Re: Project Name (File Number): Wenger (SP-07-00007)

I received a notice of application for a preliminary short plat to subdivide into three parcels for the Wenger's. I have several comments concerning the application with first starting with:

K.C.S.P. NO. 07-XX
Ptn. of the NE1/4 of Sec. 29, T.20N., R.14E., W.M.
Kittitas County, Washington

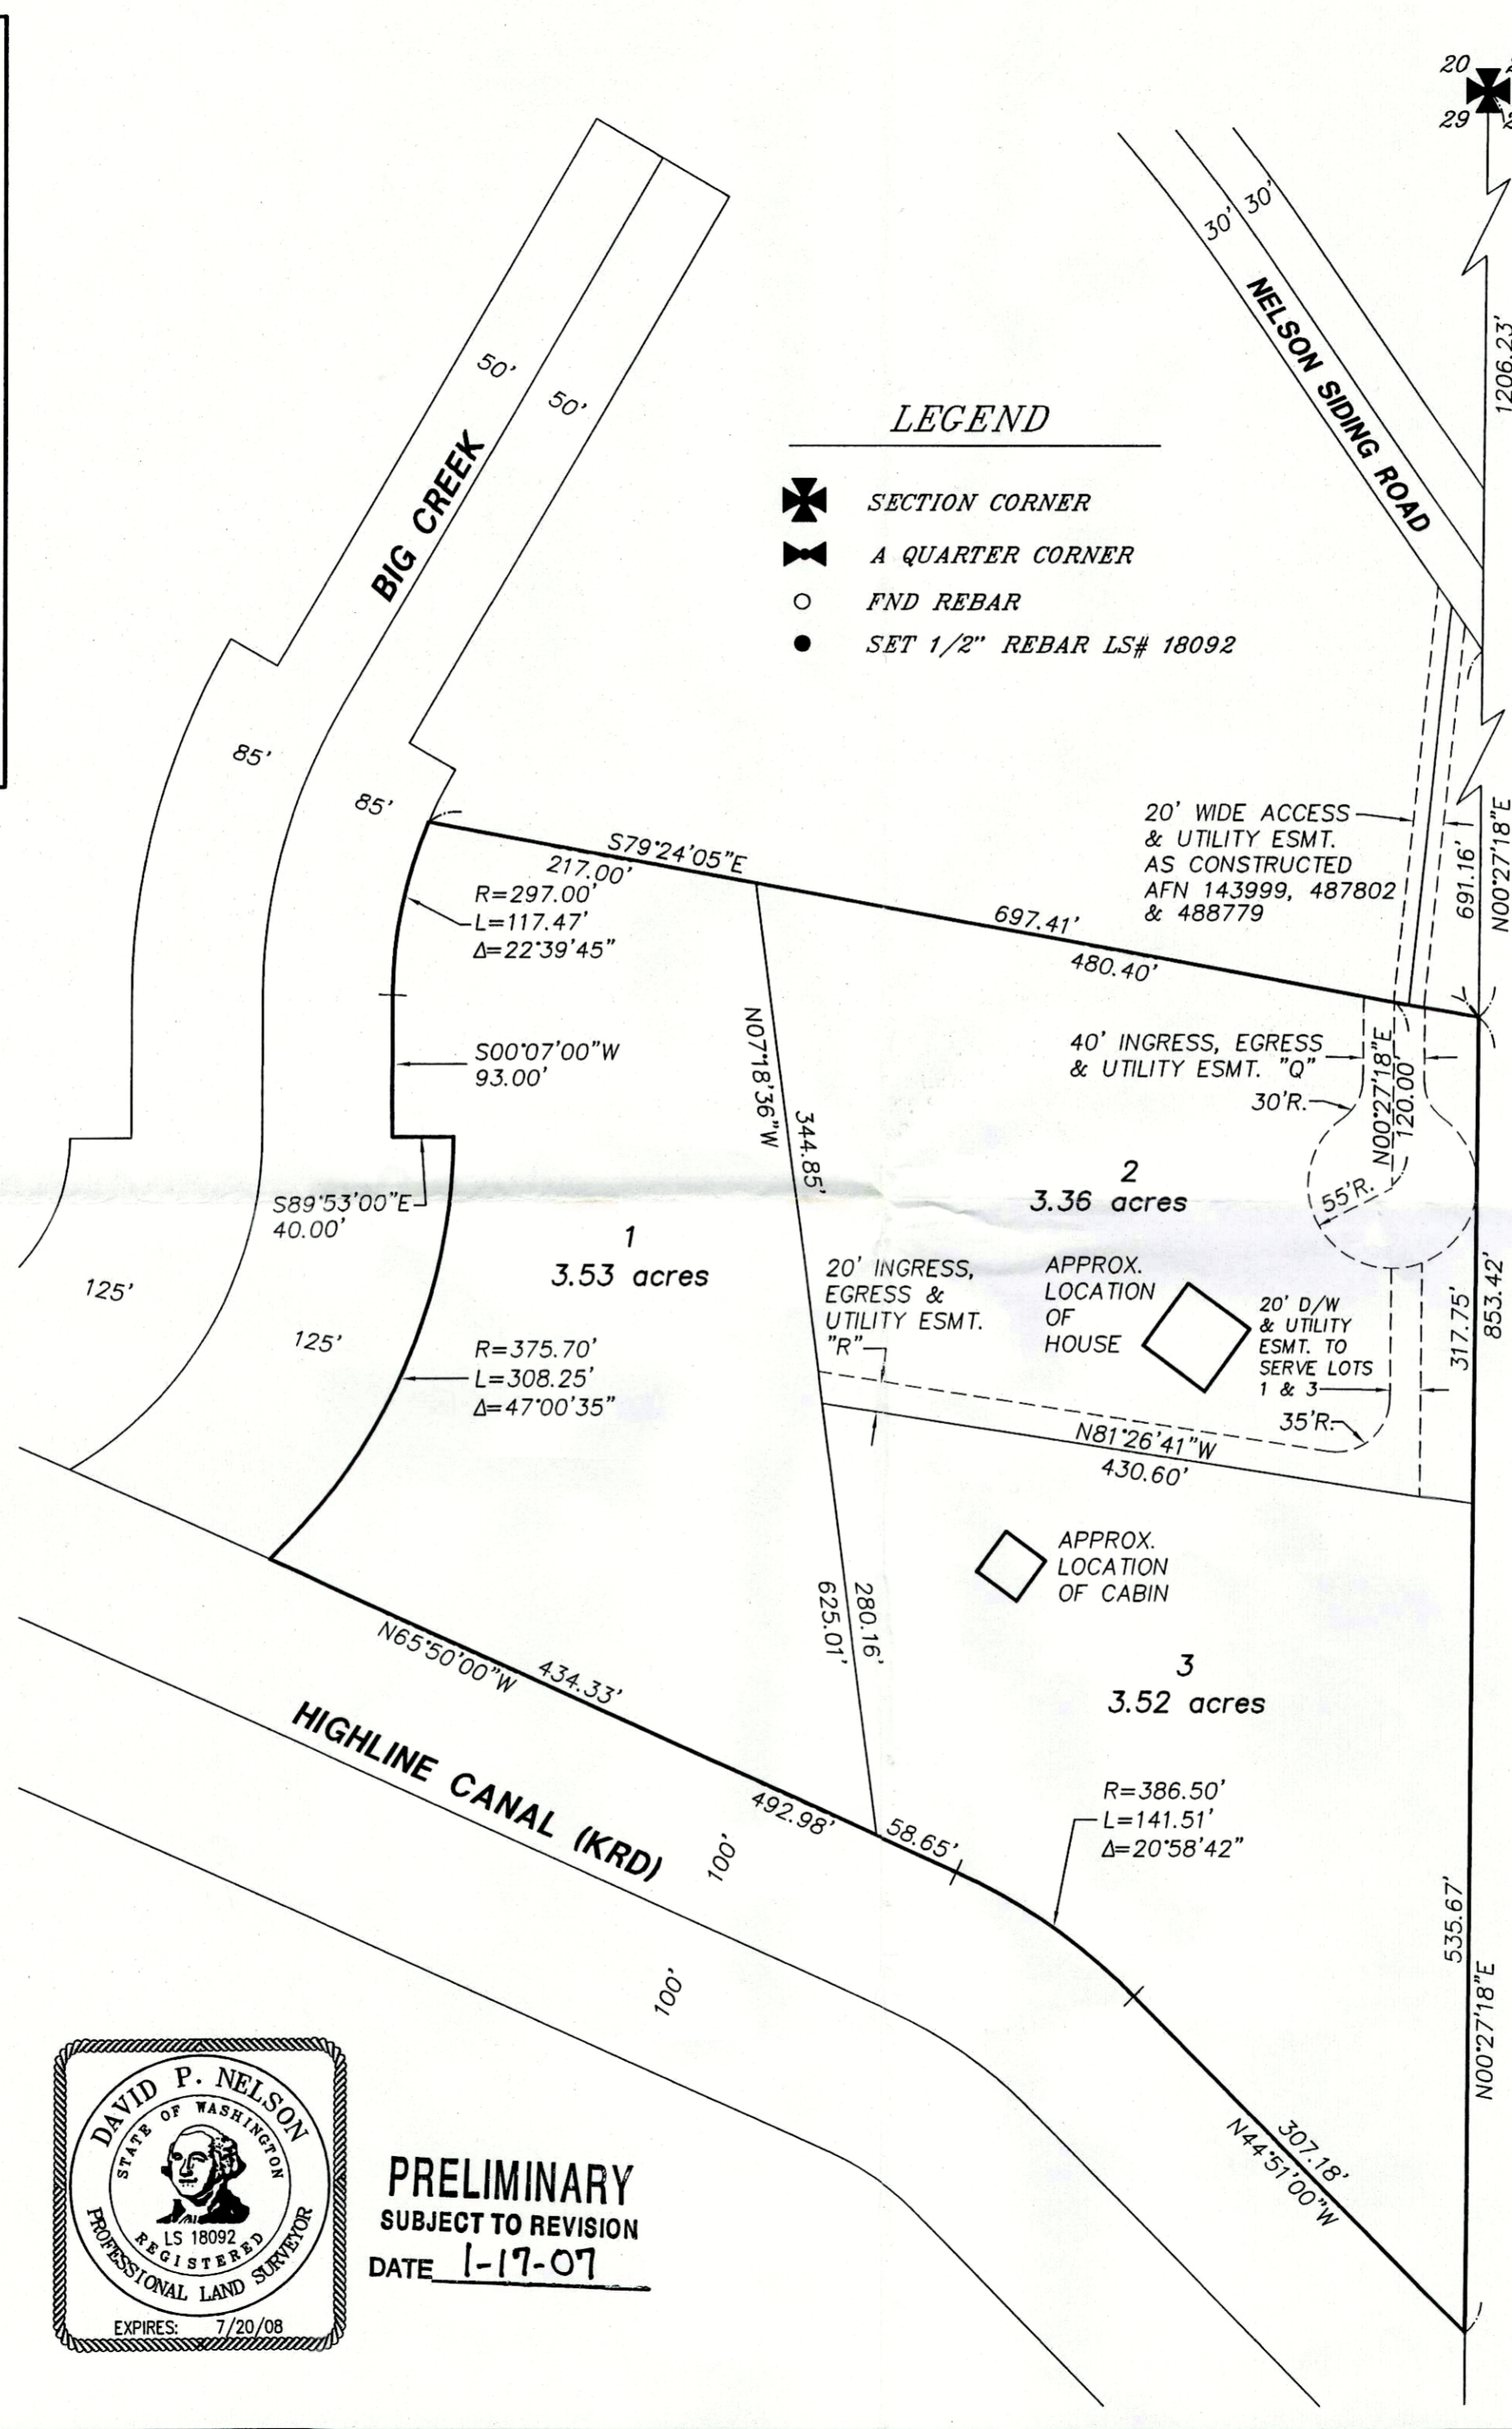
According to the Wenger Short Plat Road Variance 08-36 you have stated that a 40' easement will be required. You also stated that the access also serves two lots on the south side of the canal, which there are 3 parcels on the south side of the canal. If this plat is approved then the road is serving 8 parcels from the county road, and why are they not required to have a 40' easement from the county road?

Also stated is that BLM granted them an easement which the Bureau of Reclamation or Kittitas County Reclamation didn't give them an easement but a License Agreement of 10' which 2' can be graveled. This is only a License Agreement between United States of America and Wenger. This license is as a term of 10 year period which has to be renewed for additional consecutive 10 year extensions which is at the option of the United States. No subleases, assignments or transfer of this license shall be valid without written authorization from Reclamation. The license can be terminated at any time and all possession of the premises be put back to its original condition.

So how can you give them a 20' variance when it is not a permanent access through my property to Wenger. Where the easement road of 18' for access to Wenger's parcel has been established and maintained since 1926. The Bureau of Reclamation owns 45' which from the section line dividing Musso's and Korfus's. From the section line they own 25' of Korfus's property and 20' of Musso's property. The easement road parallels along the Reclamation, but if you measure 25' from the section line to the Korfus's easement road you get more than 25'. Our power box is located on our property not on KRD's. So for them to add 2' to 10' on to the existing road you are still on Korfus land not owned by Bureau of Reclamation.
